Our ref: NO/2017/109921/03-L01
Your ref: 3/2017/0408
Date: 26 July 2017

CHANGE OF USE OF SITE FROM RESIDENTIAL USE (C3) TO A COOKERY SCHOOL WITH ASSOCIATED ACCOMMODATION (C2), INCLUDING AN EXTENSION TO THE EXISTING DETACHED GARAGE BUILDING

THORNEYHOLME HALL NEWTON ROAD DUNSOP BRIDGE BB7 3BB

ARCHITECTURE
Title
Proposed Cookery
School General
Arrangement

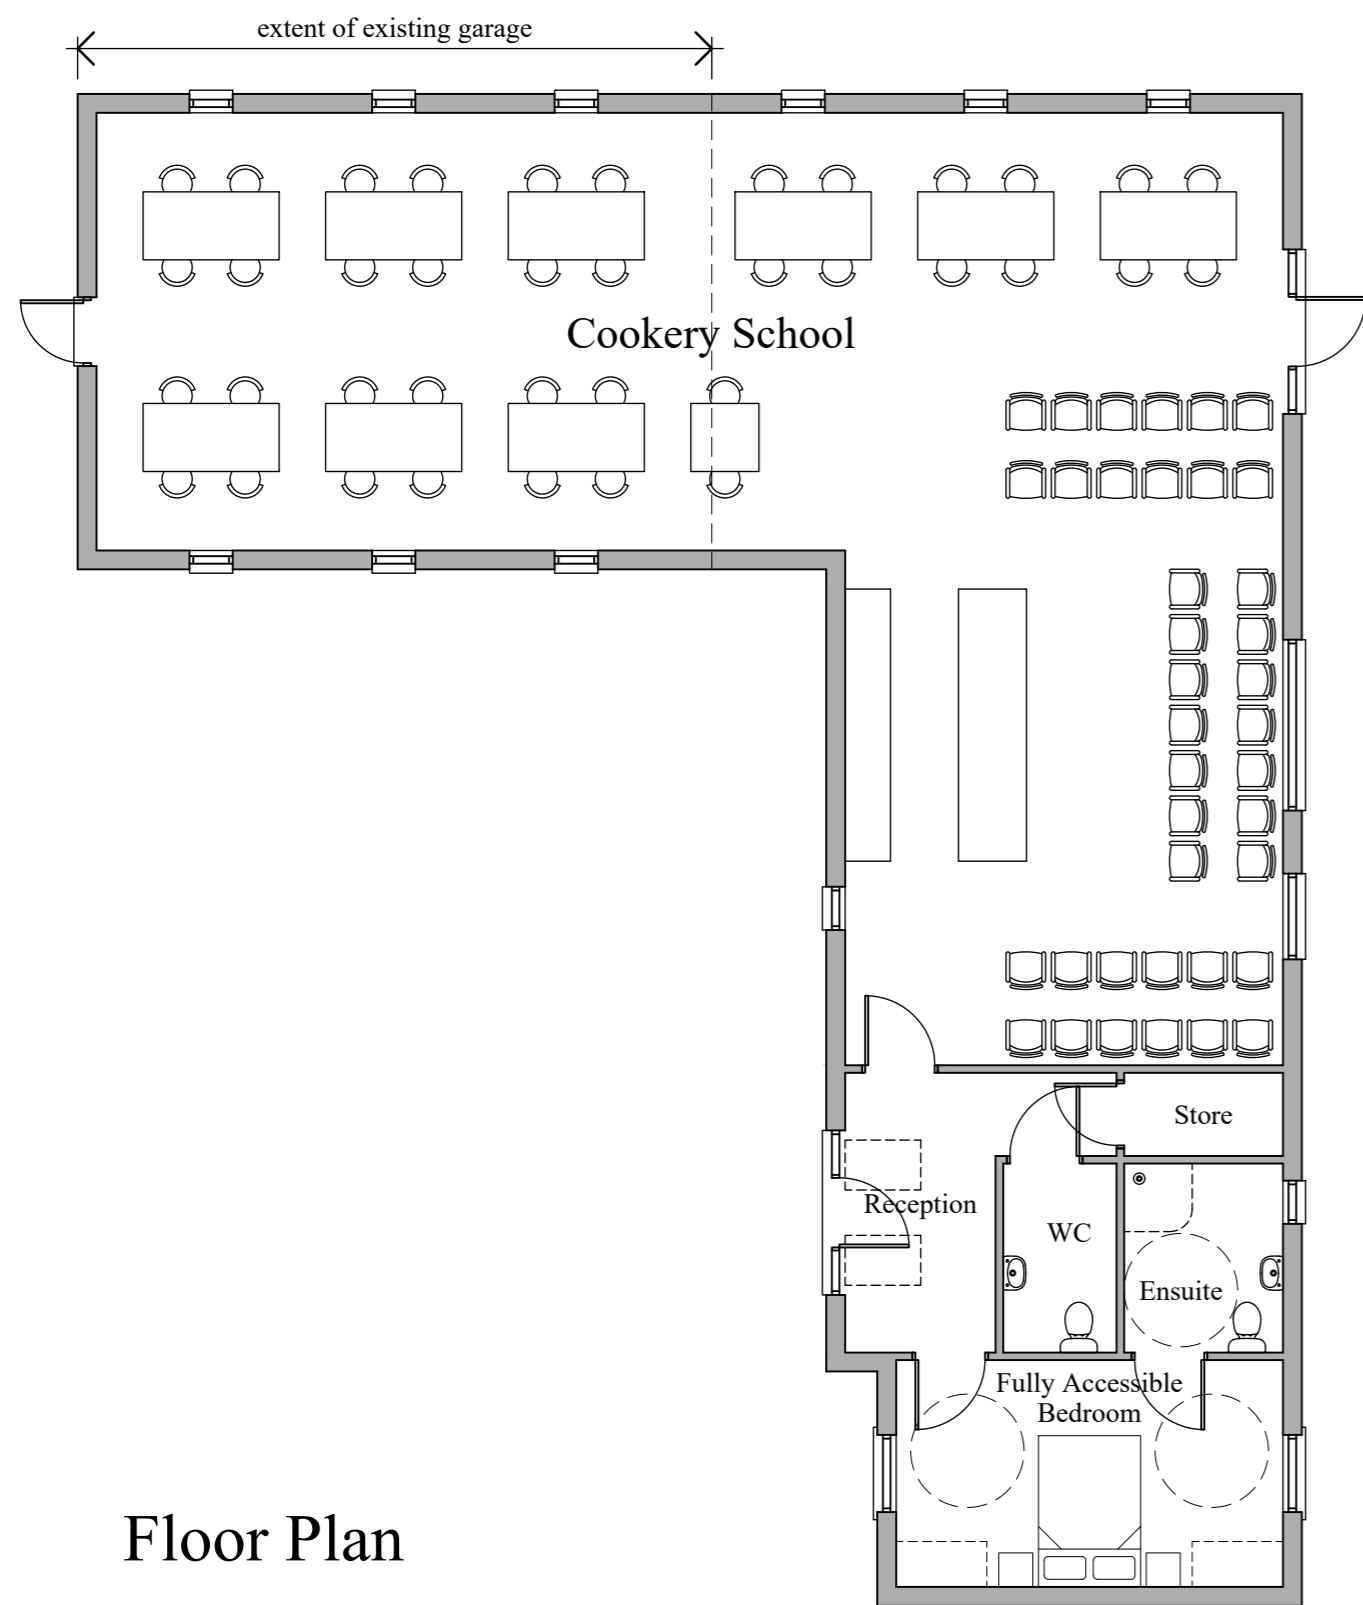
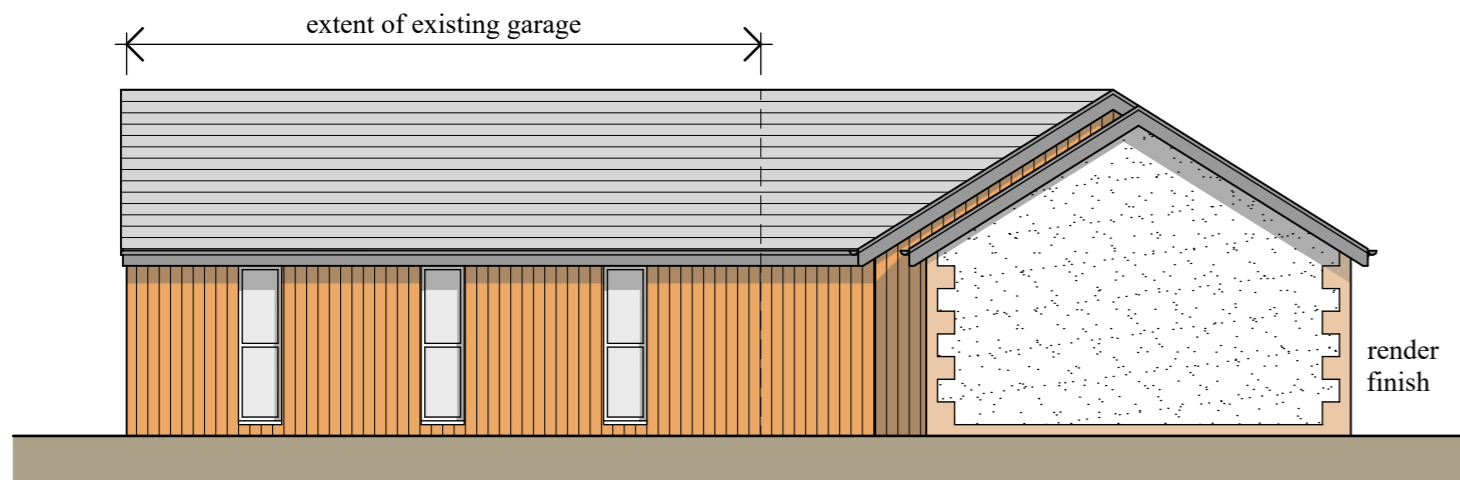
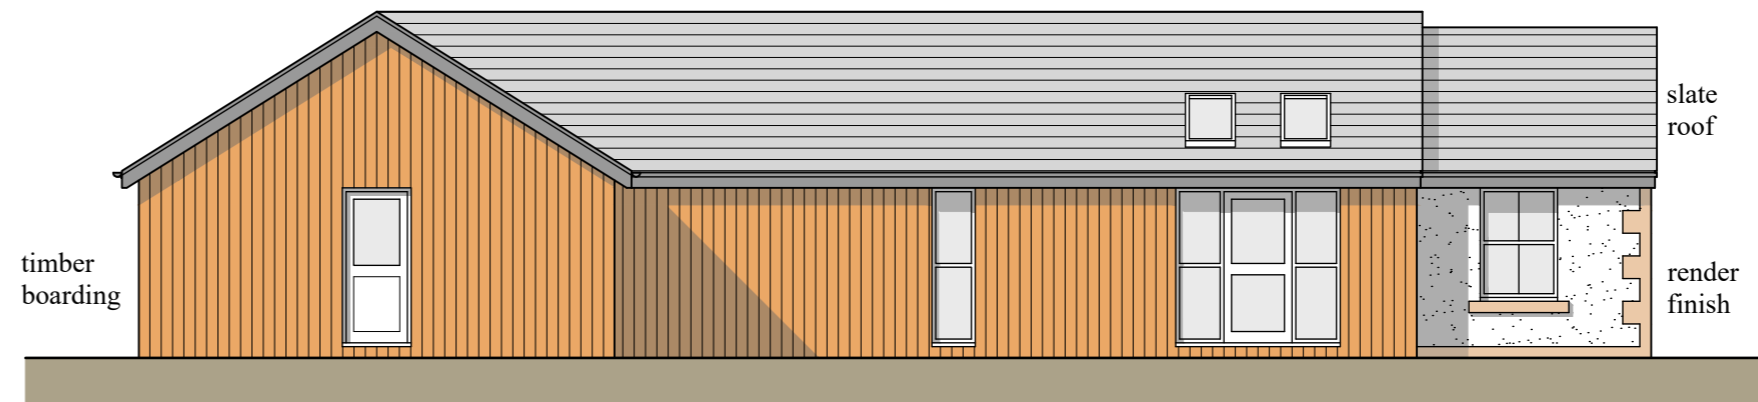
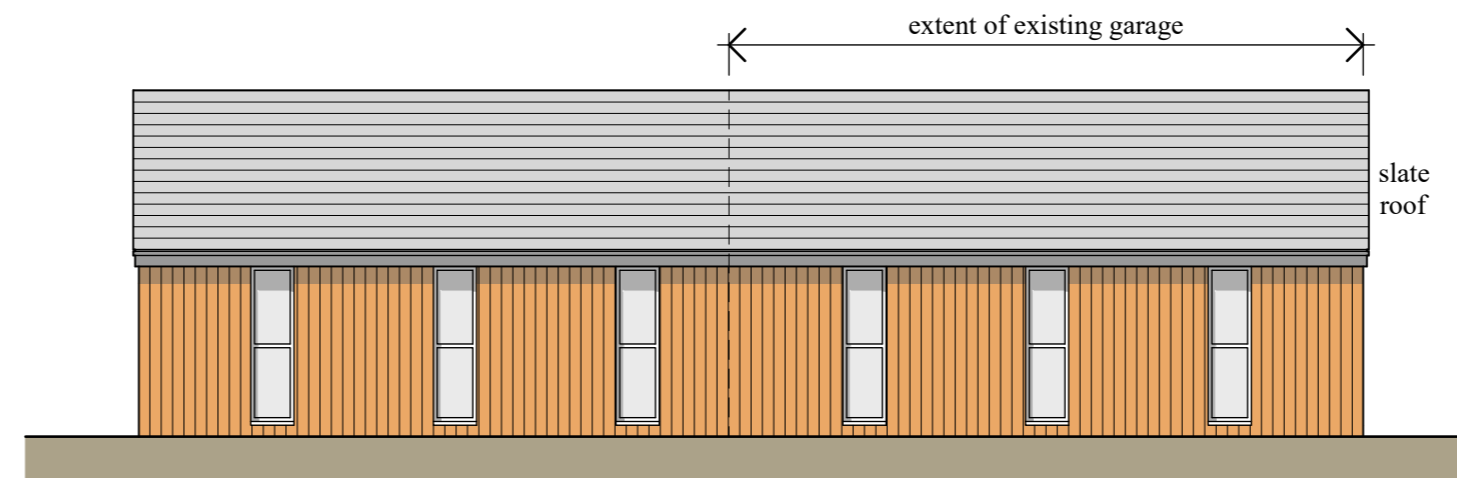
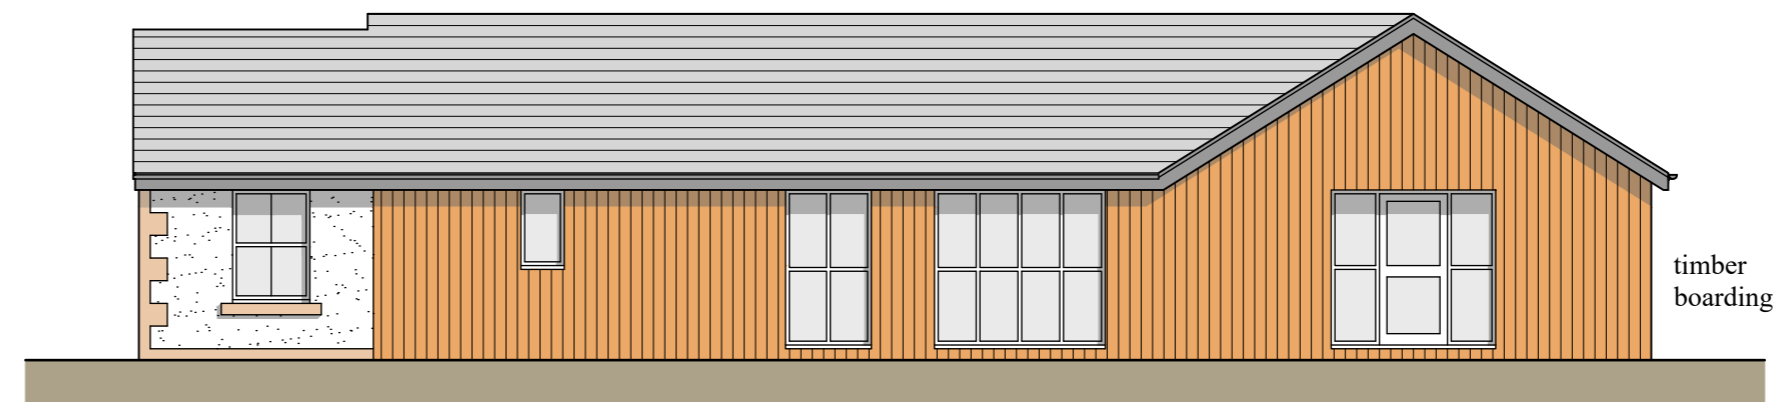
- Proposed cookery school general arrangements (drawing no. 1178-PL-23C Rev C; dated 24/07/17)

We **withdraw our objection** to the proposed development as the revised plan now confirms that it is no longer propose to include any bedroom accommodation within the cookery school building.
